City of Albuquerque

May 28, 1991

RE: DRAINAGE PLAN FOR NM 1-3, PHASE 2 HOUSING, W.O. No. 4163
(L-15/D38) ENGINEER'S STAMP DATED MAY 20, 1991

GRADING AND DRAINAGE PLAN

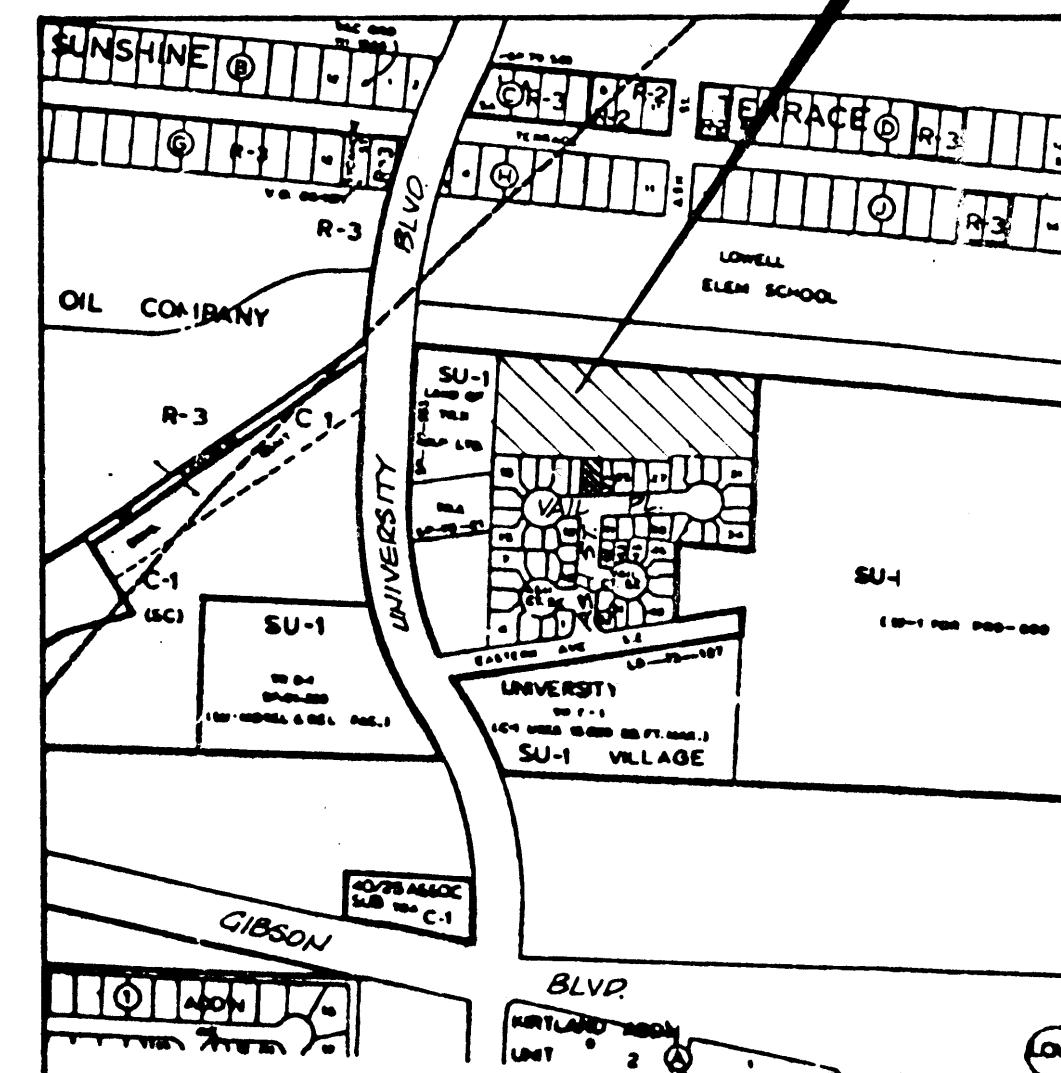
1. Type "C" inlets should be specified only downstream from a type "A" inlet. The reason being is the "A"s have a debris sweeping capability with the throat; therefore eliminating debris from clogging the grate.
 - a. The No. 2 inlets identified on your plan should be substituted for type "A"s with a throat on the upstream end.
 - b. The No. 1 inlet in Ross Court should be substituted for an "A" with a double throat.
2. I would like to discourage the type "D" inlet you are proposing at Vail Place. Reason being is the type "D" has caused previous litigation for the City because of bicyclist accidents, since it is out in the traffic lane.

ROSS COURT PLAN & PROFILE

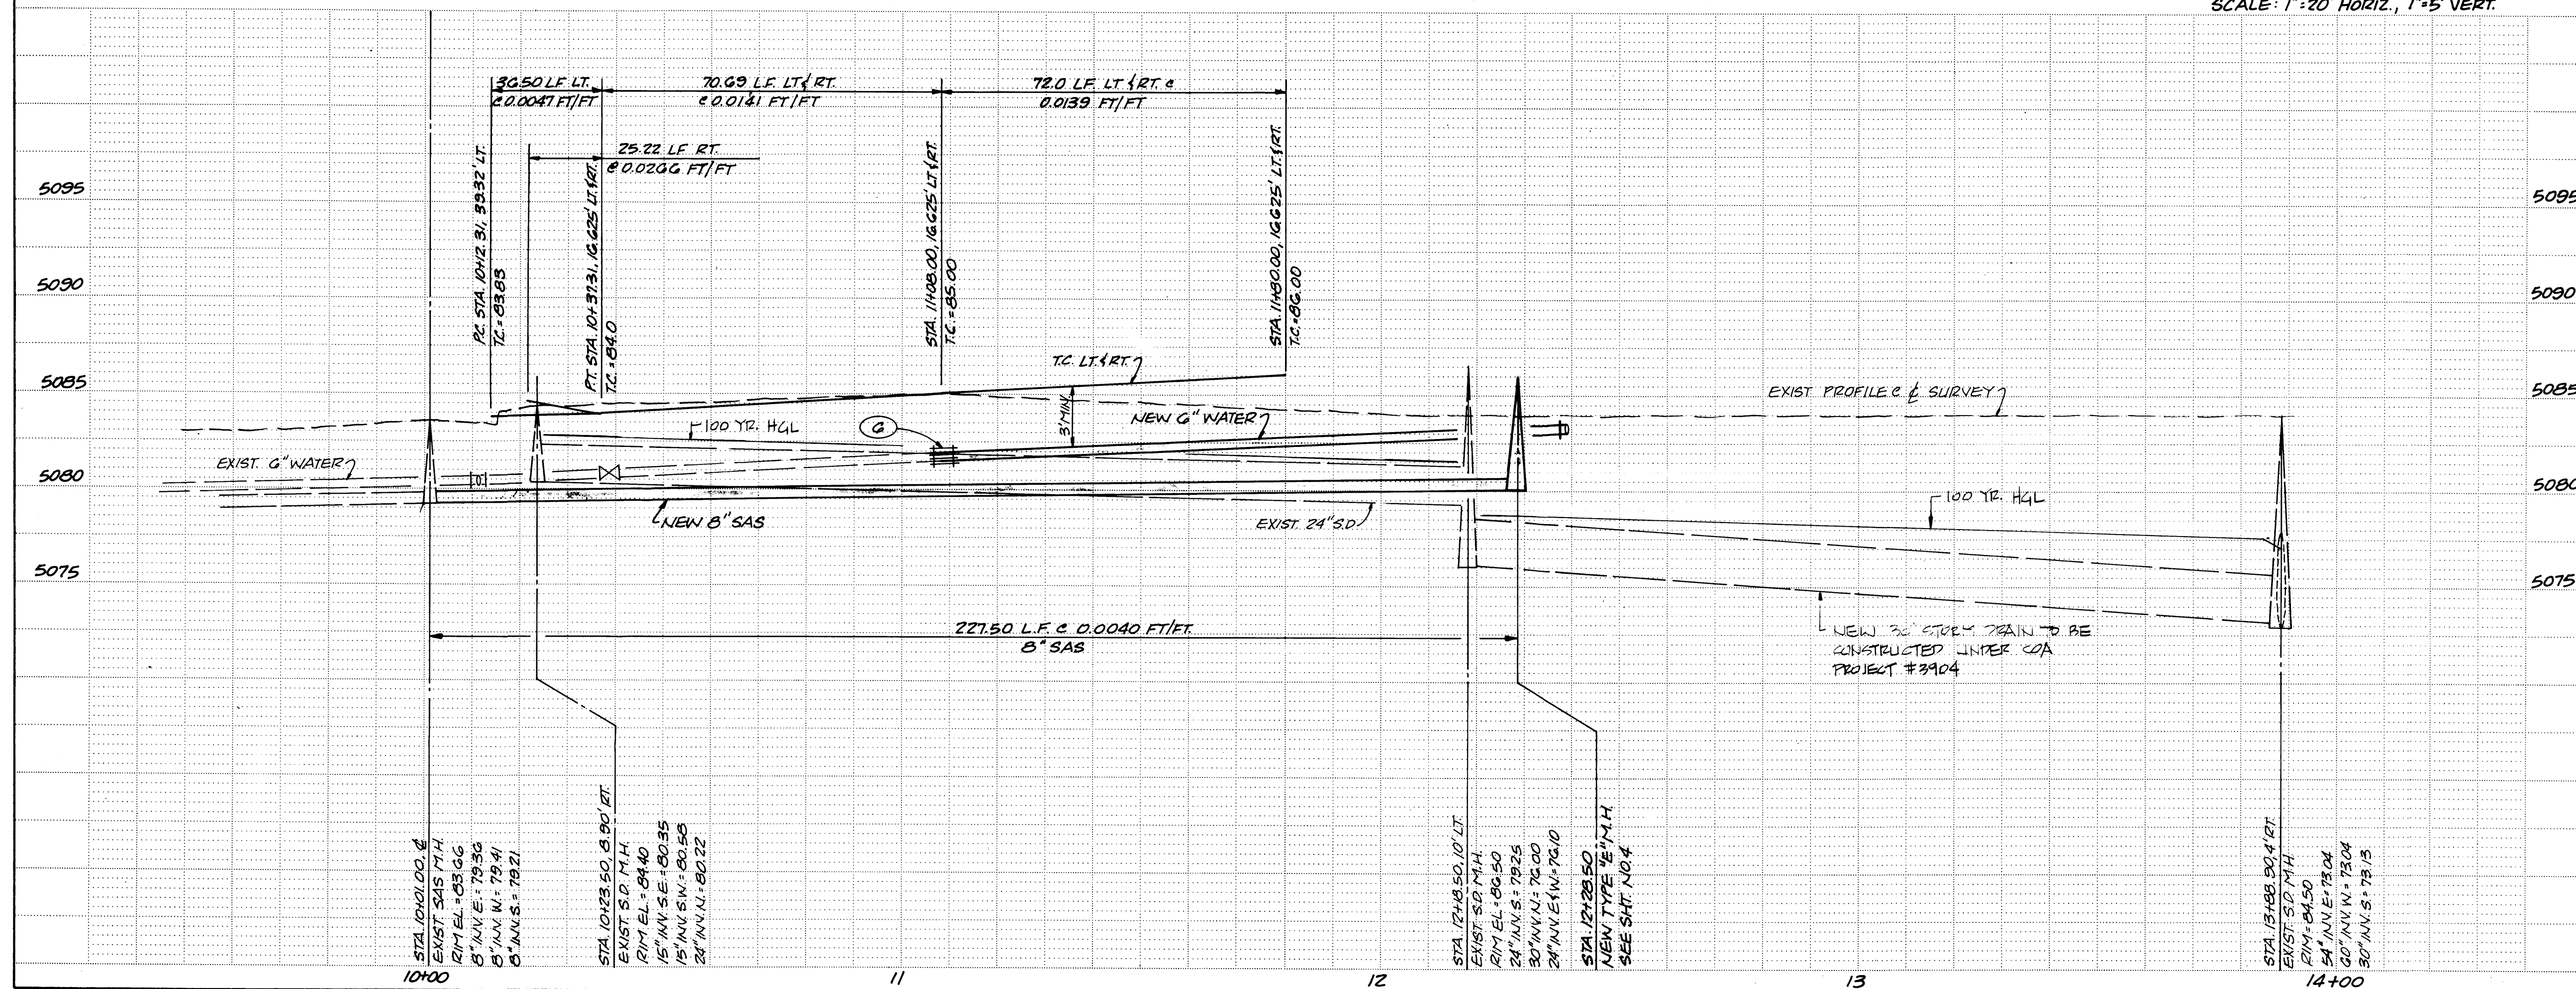
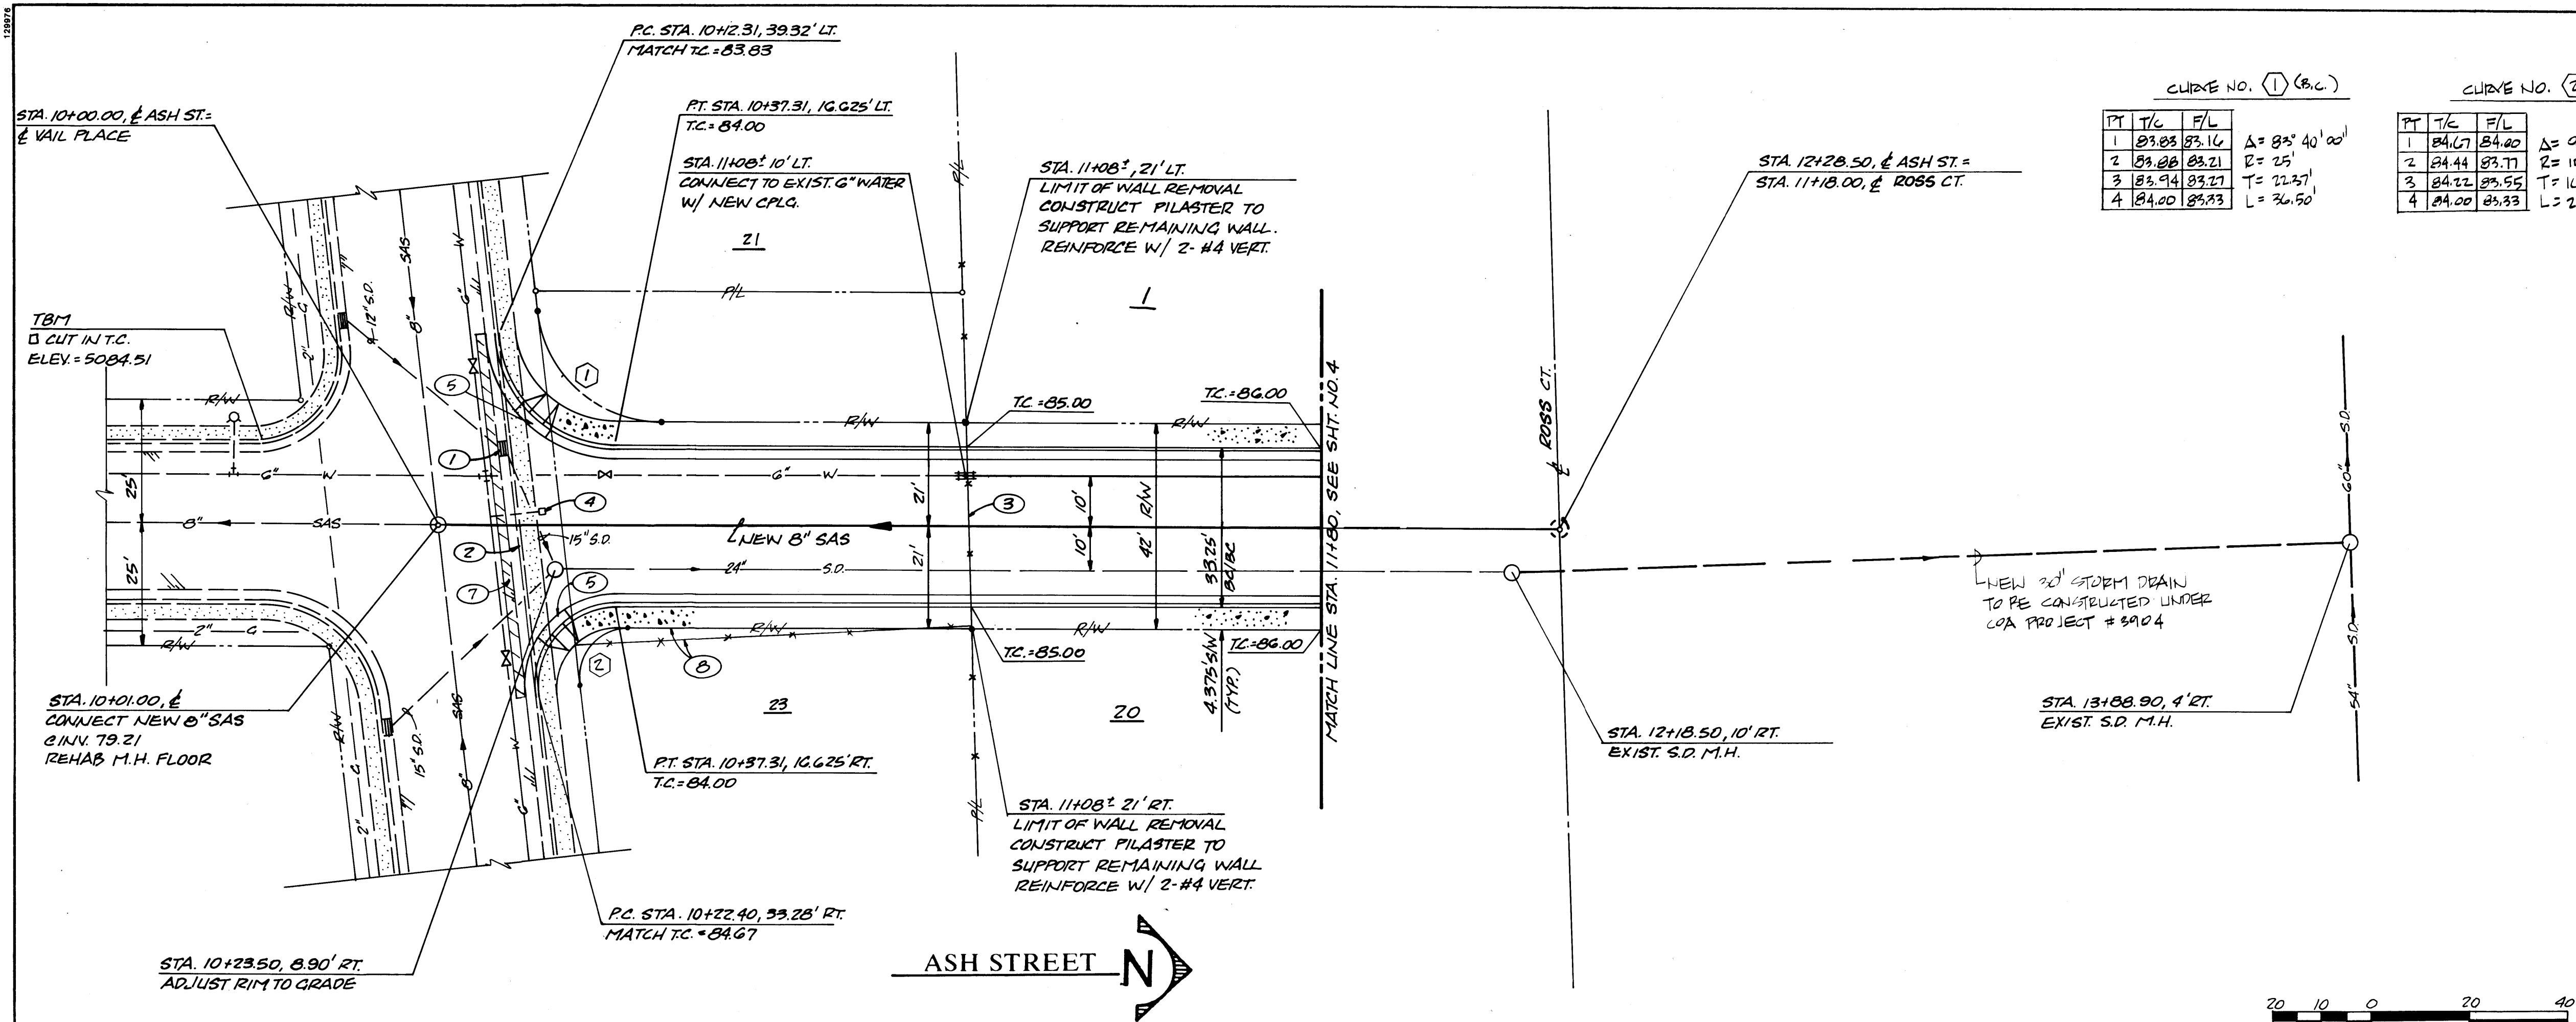
3. Is there a reason for the severe vertical street undulation you are proposing for Ross Court.
4. What is the maximum height of the retaining wall being proposed?
